BUSHFIRE HAZARD ASSESSMENT REPORT

REPORT PREPARED IN RELATION TO:	RESIDENTIAL SUBDIVISION
PROPERTY DESCRIPTION:	PART LOT 112 DP 1073791 off LYONS ROAD, TOORMINA, via SAWTELL.
REPORT COMMISSIONED BY: (my Client)	Utila Pty Ltd, c/- Mr Adrian Borsato
	DATE ISSUED:

ROAD PROFILE 7

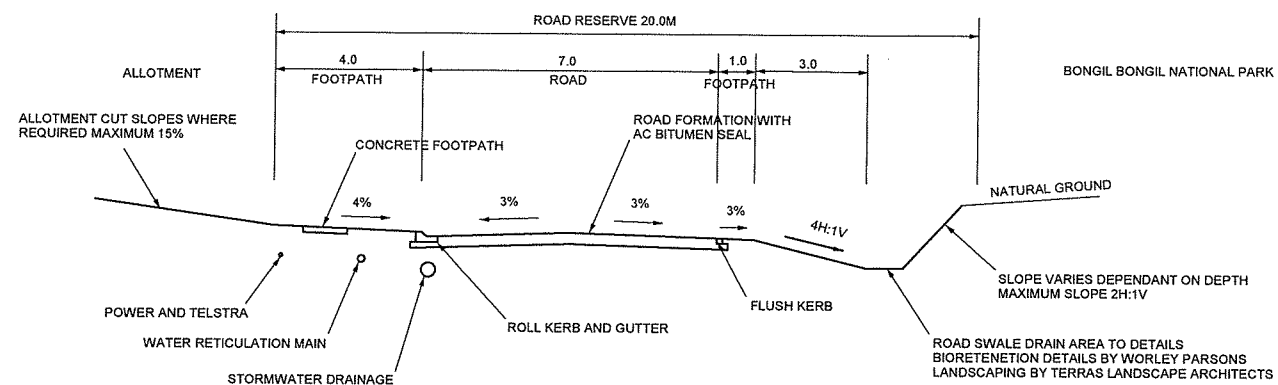
- Road profile number 7 indicates that the perimeter road has a proposed carriageway width of 7 metres. The requirement is 8 metres similar to proposed Roads 5 & 6;
- Suitable turning provisions shall be provided at the eastern end of Road 8;
- Is the Road 8 loop road proposed as a one way road;
- The use of fire trails in the adjoining land to the east and south of the site should be referred to the adjoining land owner for advice.

- o All of the road widths need to be rechecked to ensure compliance with the relevant *Acceptable Solutions* of **PBP-2006**. As stated in the previous versions of my Report, "All of the *Acceptable Solutions* above are able to be incorporated into the design of the public road network for the proposed subdivision."
- o See note above.
- o The road layout has been amended to create a cul-de-sac (dead-end road).
- o The National Parks and Wildlife Service were consulted on 13/1/2010 to seek an assurance that the fire trails on the adjacent NP were to be maintained in a bushfire
